**PUBLIC WORKS DEPARTMENT**  
Post Office Box 9010 Addison, Texas 75001-9010

September 19, 2007

Re: Plan Review  
Sidewalk Construction Plan for Trinity Christian Academy

**SIDEWALK CONSTRUCTION PLAN**  
 TRINITY CHRISTIAN ACADEMY  
 CITY OF ADDISON, DALLAS COUNTY, TEXAS

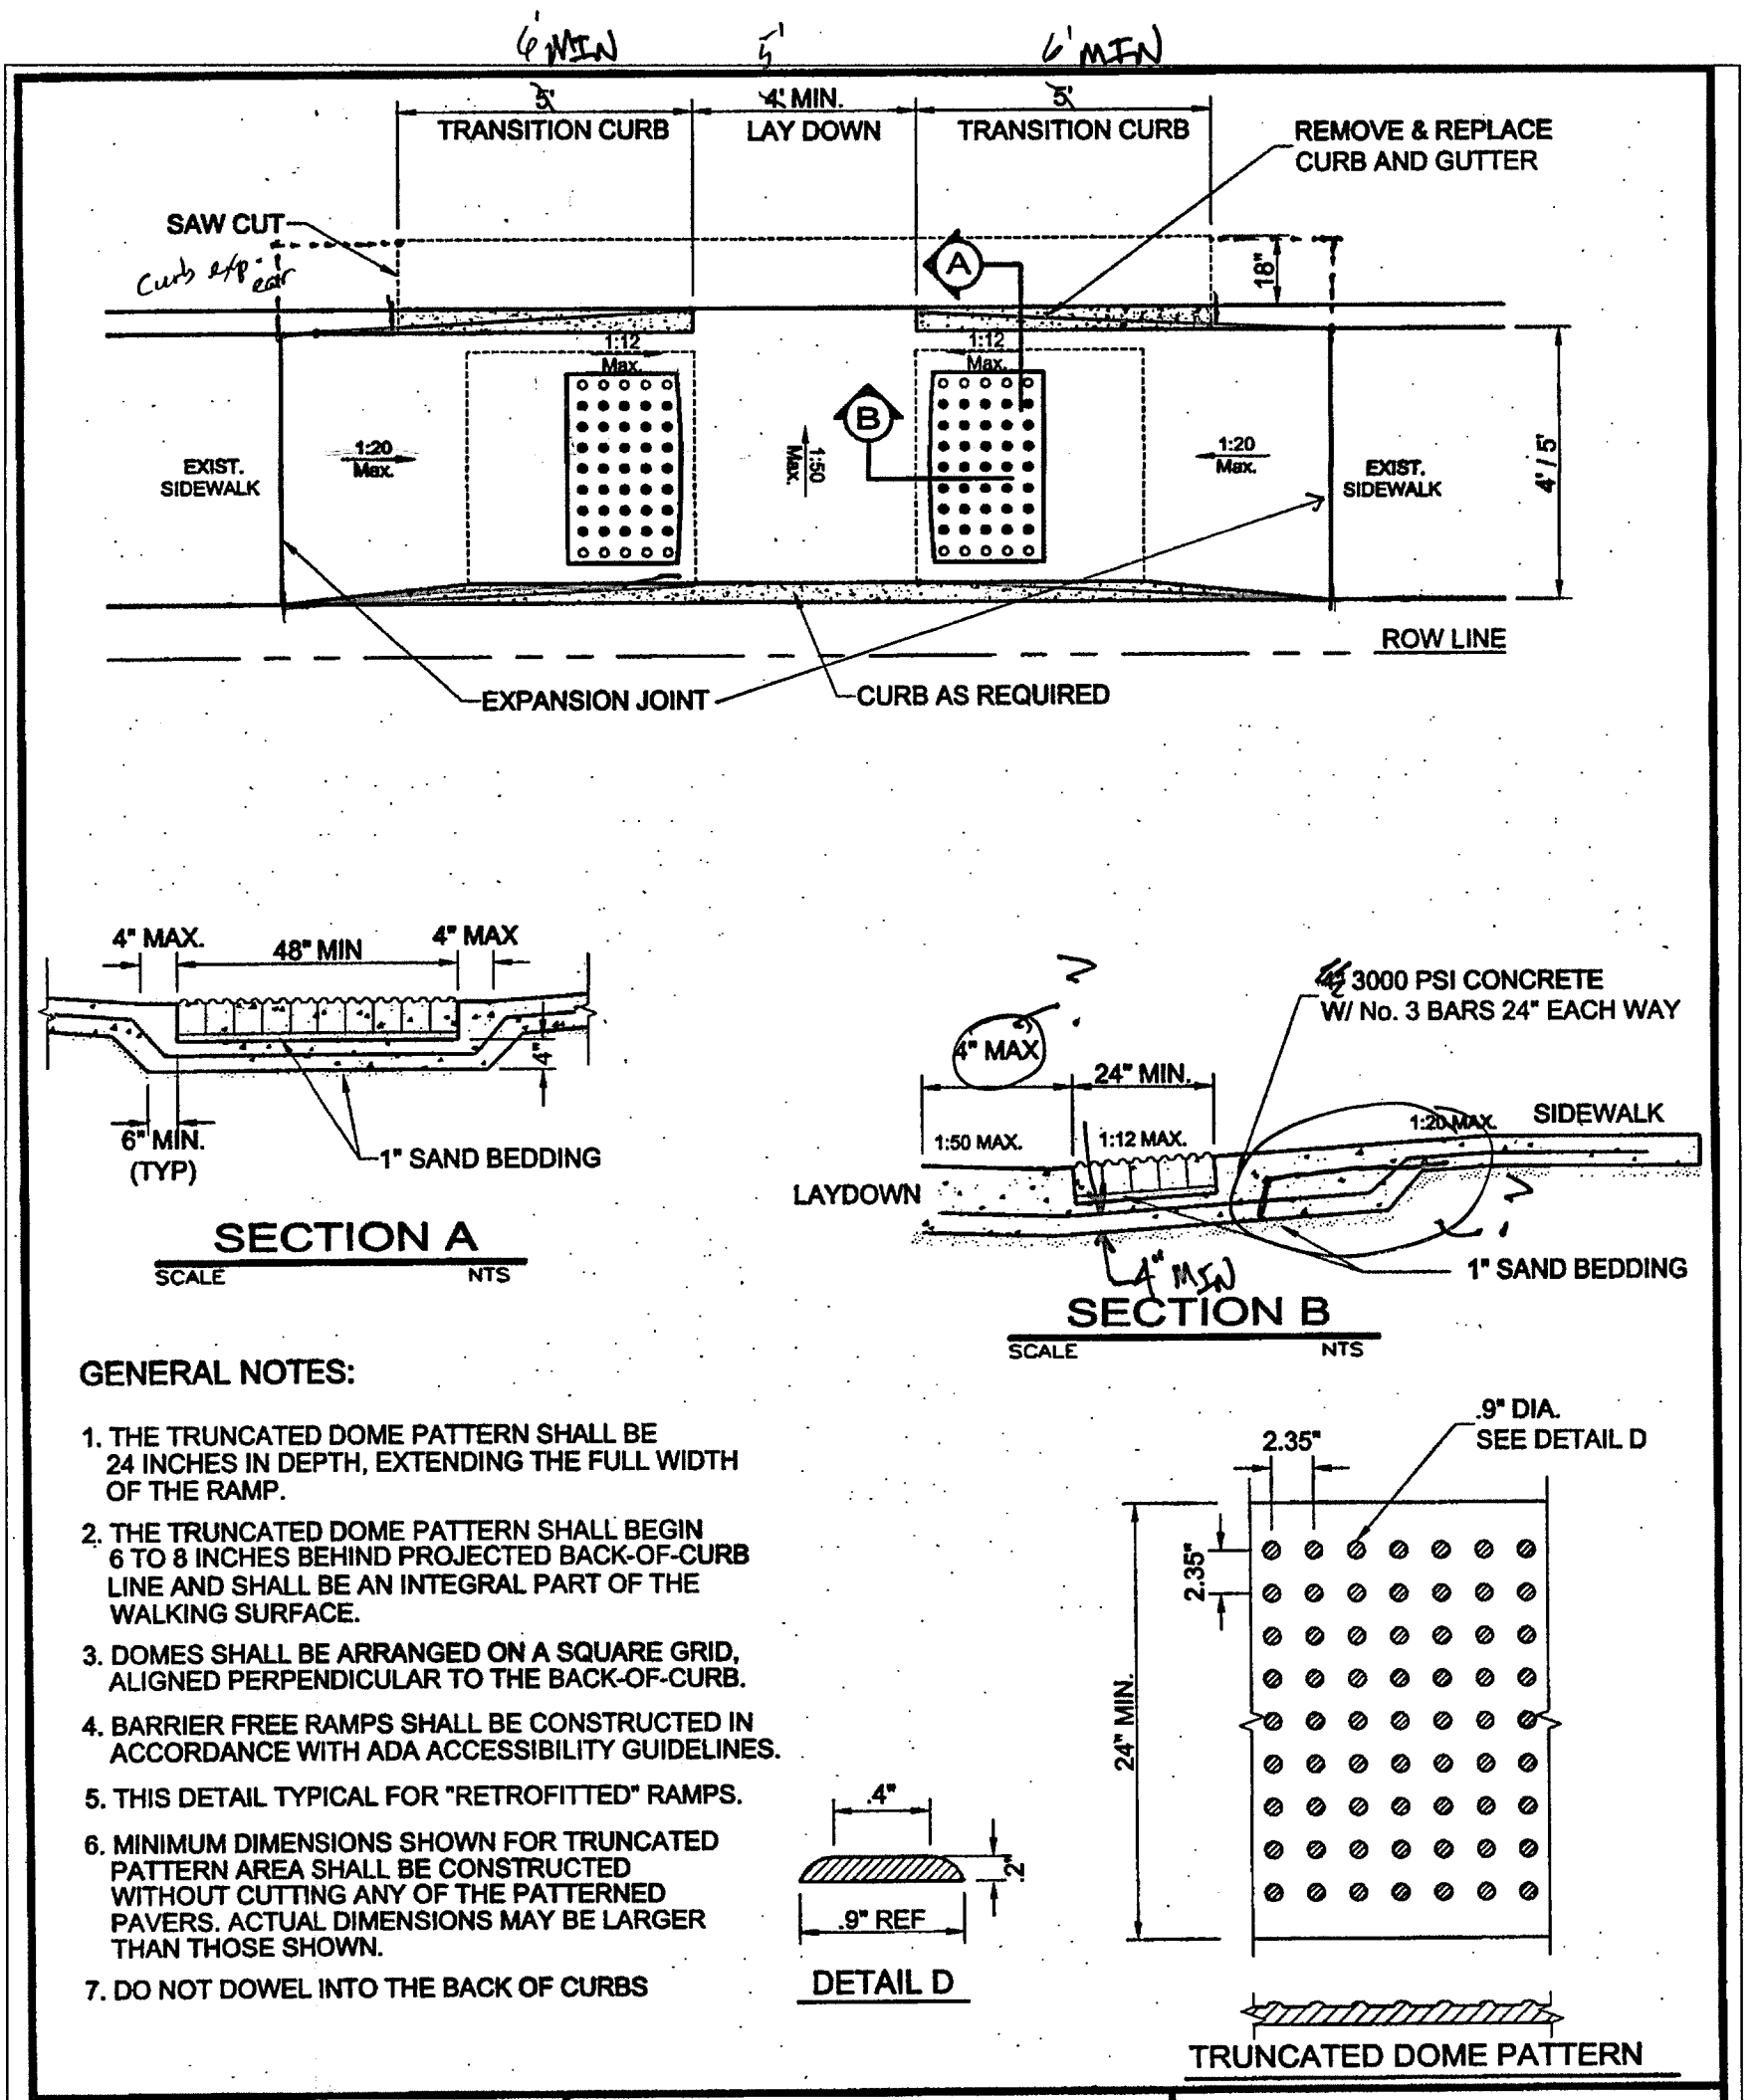
1. Please draw the crosswalk in accordance with the traffic study. Indicate that it is to be constructed of thermoplastic.
2. Please indicate the location of the signs.
3. Please revise the accessible ramp as indicated.
4. Please add a barrier free ramp at the end of the sidewalk at the existing drive. The ramp can be similar in configuration to the detail shown on the plans.
5. Place the details shown in the included specification for concrete sidewalks on the plan.
6. Callout "place 1/2" bituminous expansion joint material between the proposed sidewalk and the existing screening wall. Depth of the material shall be sufficient to prevent contact between the proposed sidewalk and the existing screening wall."
